# City of Albuquerque Stormwater Construction Site Inspection Report

Project Name and Location	Cleveland Middle School Track Comanche & Nadeau		
Site Contact Name & Agency	Richard Miller APS	Contact Phone #/ E-mail	
Date of Inspection	4-25-17	Start/End Time	11:25/11:30
Inspector Name, COA Dept.	Curtis Cherne, Stormwater Quality		
Inspector Phone / E-mail	505-924-3420/ccherne@cabq.gov		
Inspector Qualifications	Qualified Compliance Inspector of Stormwater- Stormwater One		
Describe Present Phase of Construction	Track paved

**From:** Cherne, Curtis  
**Sent:** Monday, April 10, 2017 8:07 AM  
**To:** Graeme Means (gmeans@highmesacg.com)  
**Subject:** Cleveland MS Track and Field grading  
**Attachments:** grading\_north\_area.jpg

**GRADING PLAN**  
**TRACK AND FIELD IMPROVEMENTS**  
**CLEVELAND MIDDLE SCHOOL**  
**6910 NATALIE AVENUE N.E.**

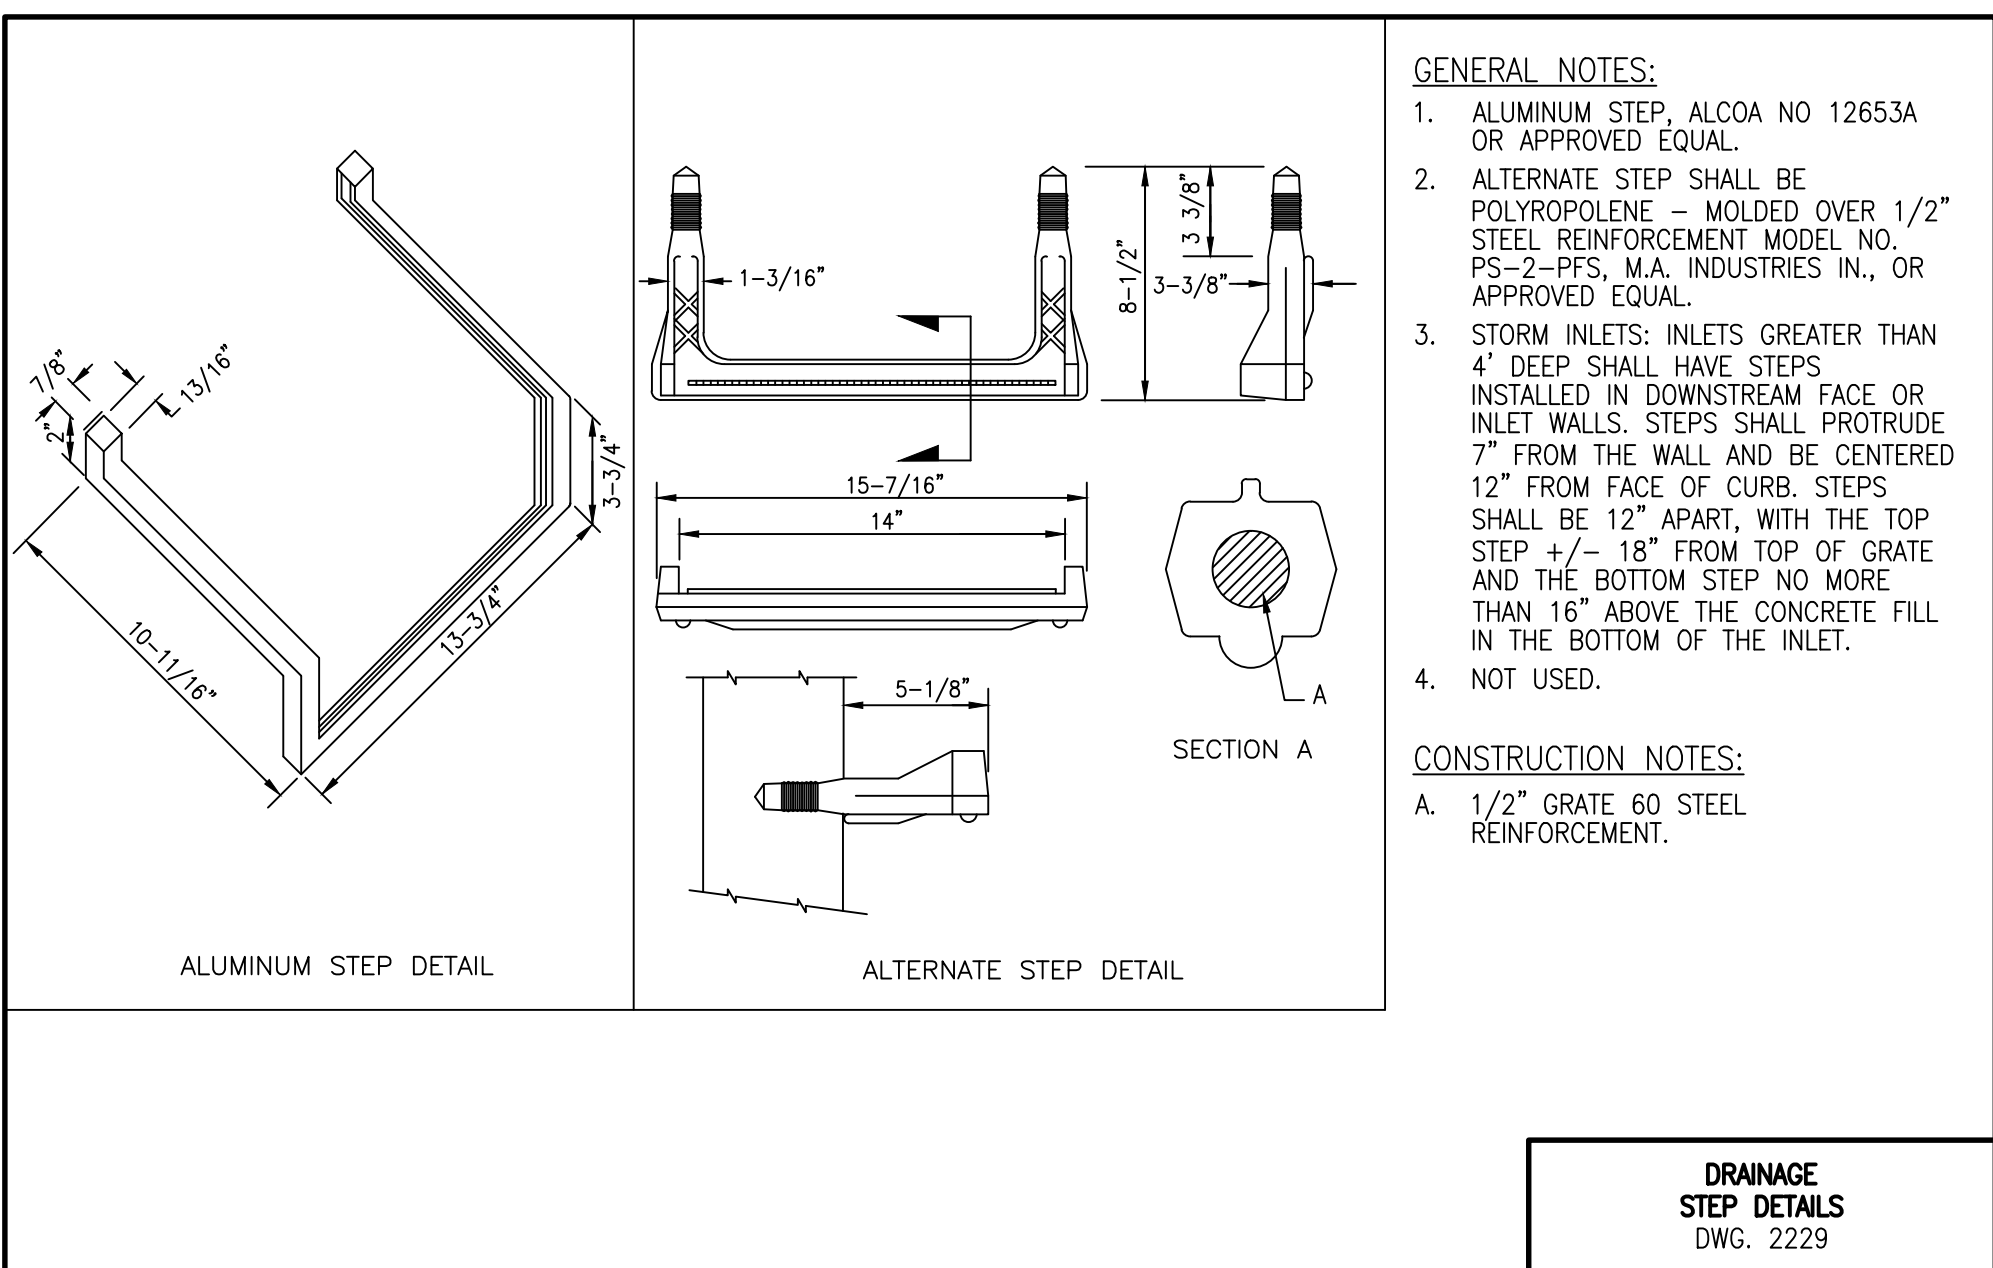
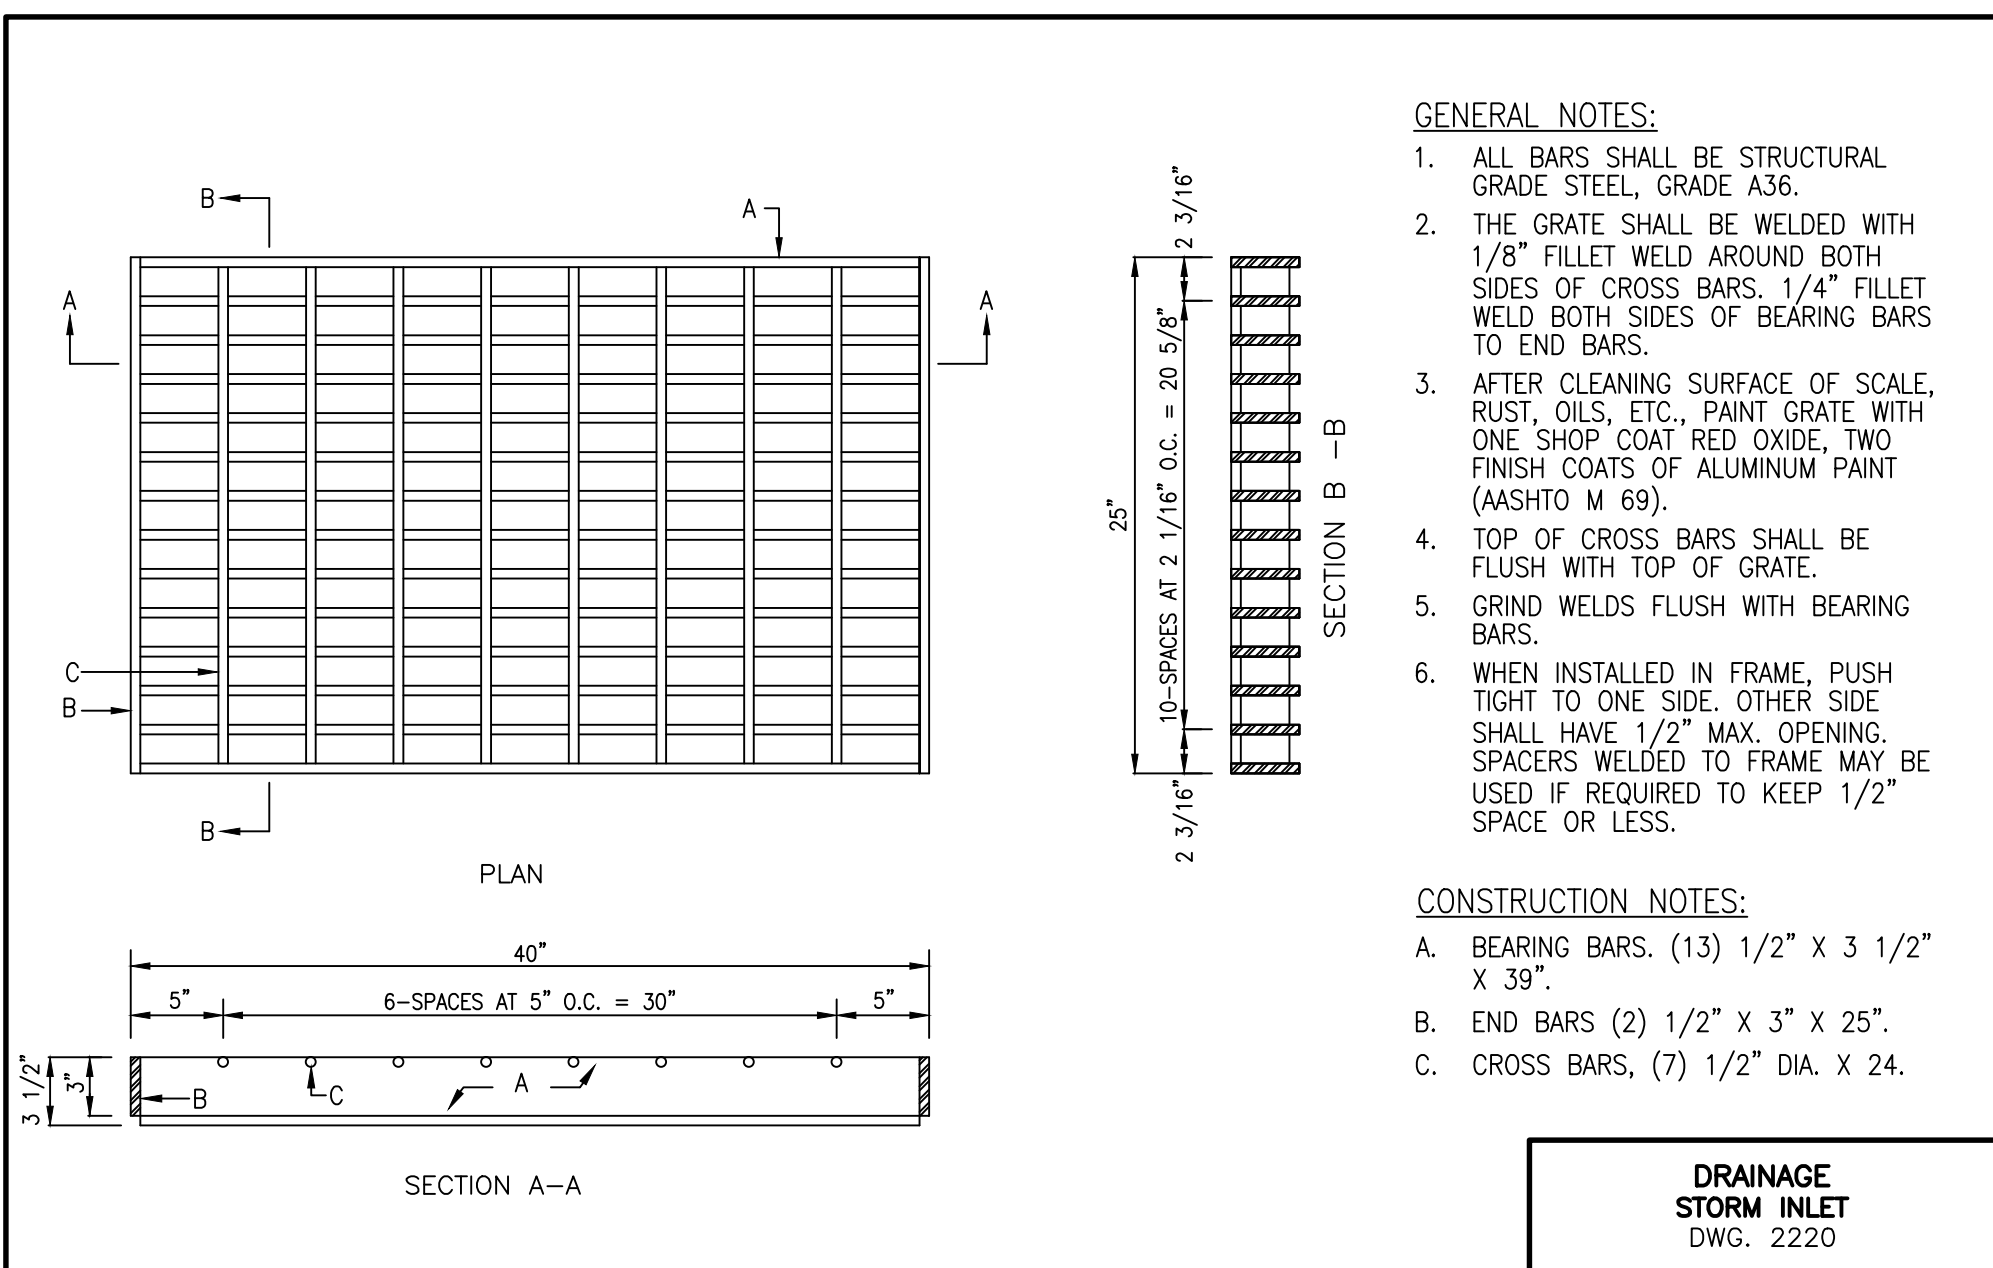
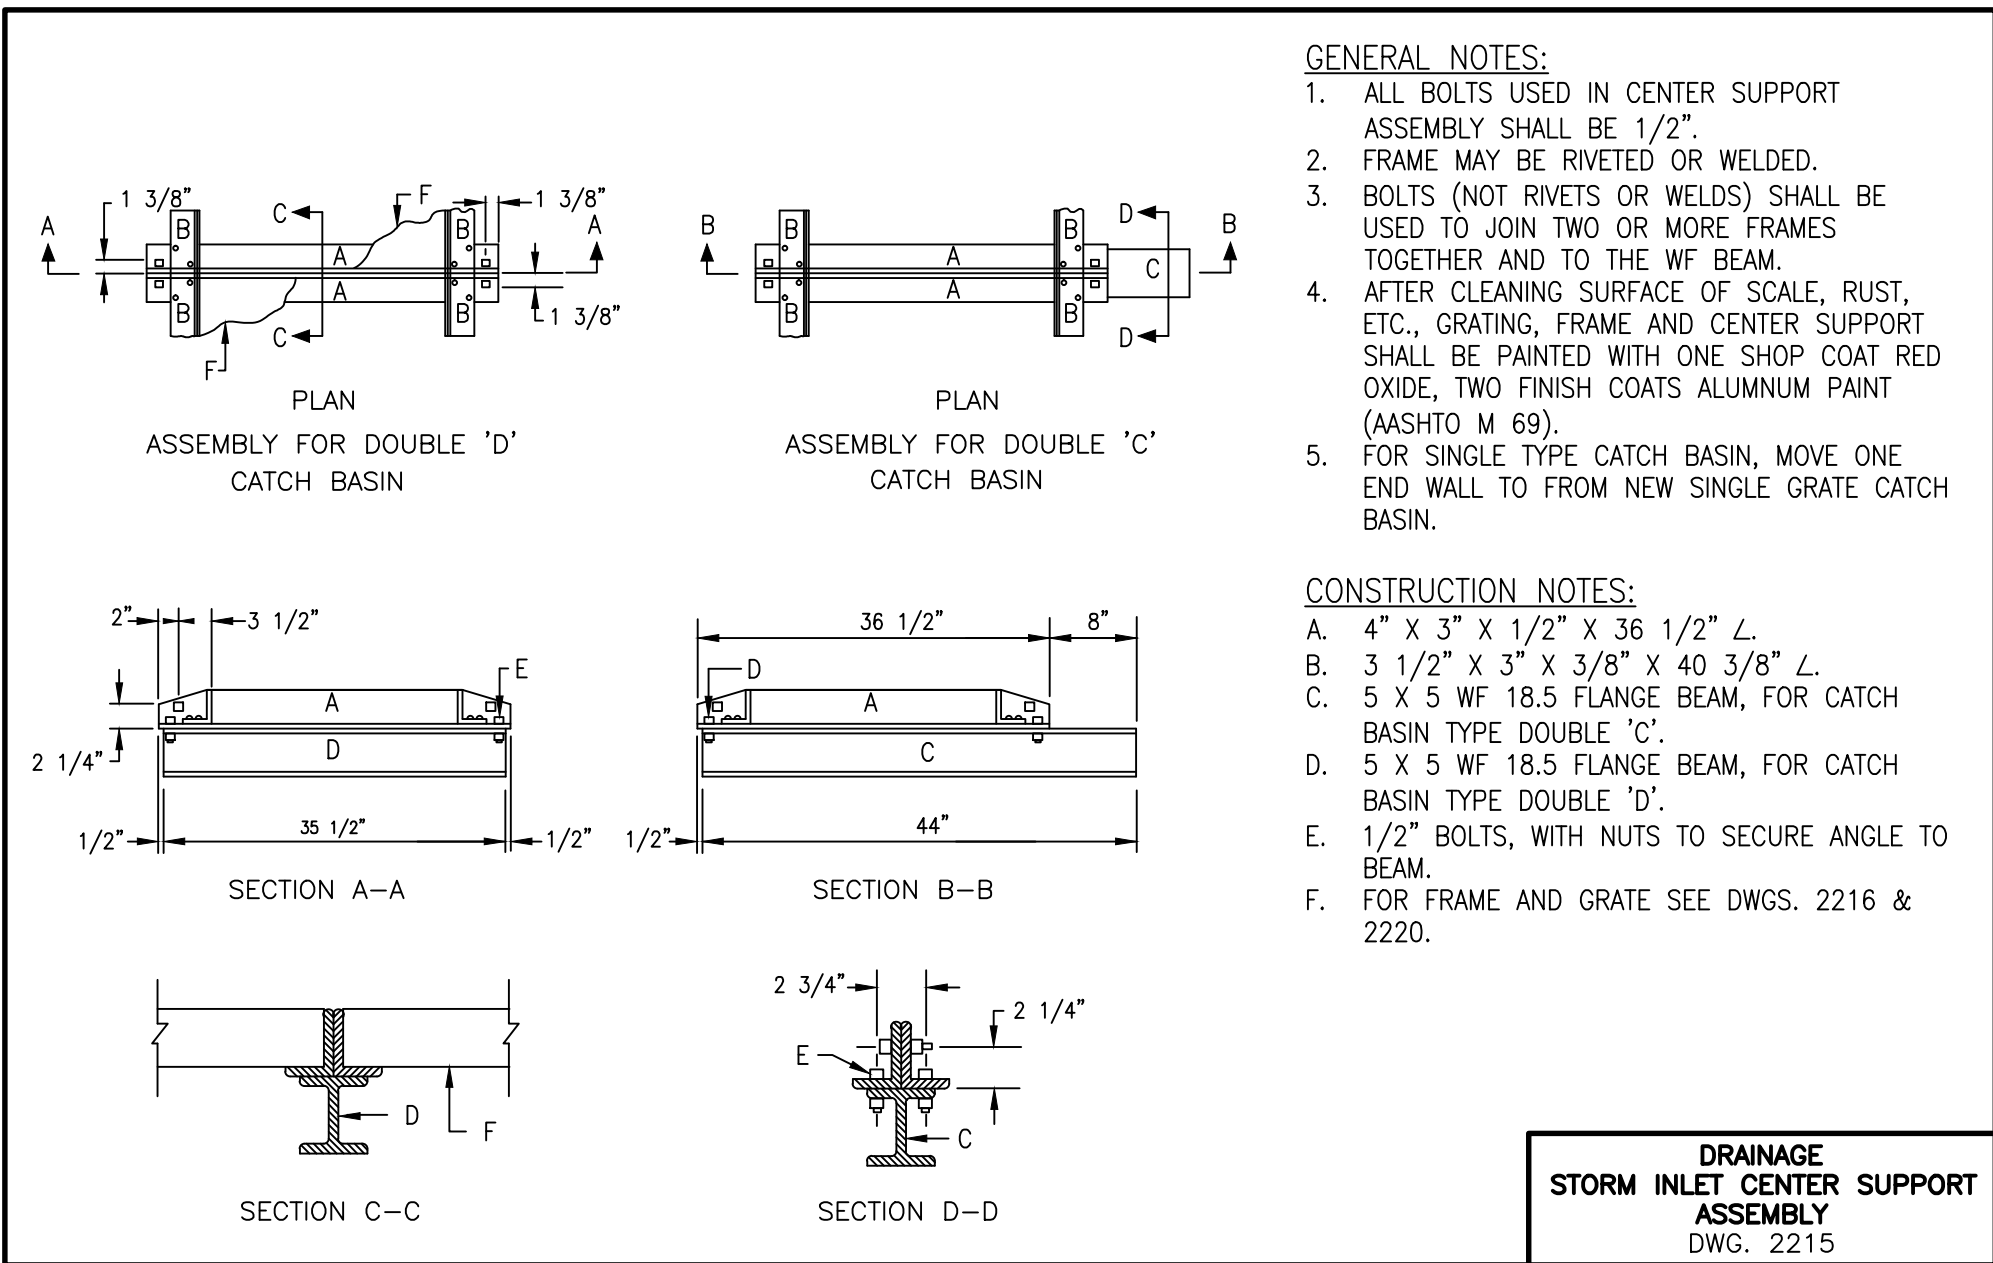
Altor was grading north of the basketball court (see attached photo).

I asked them why they were grading here as it is not shown on the plan and the supervisor told me that APS did not wish to export, but decided to spread-it-around.

I don't know if the change in grade adversely affects the drainage plan for the site, but I wanted to let you know.
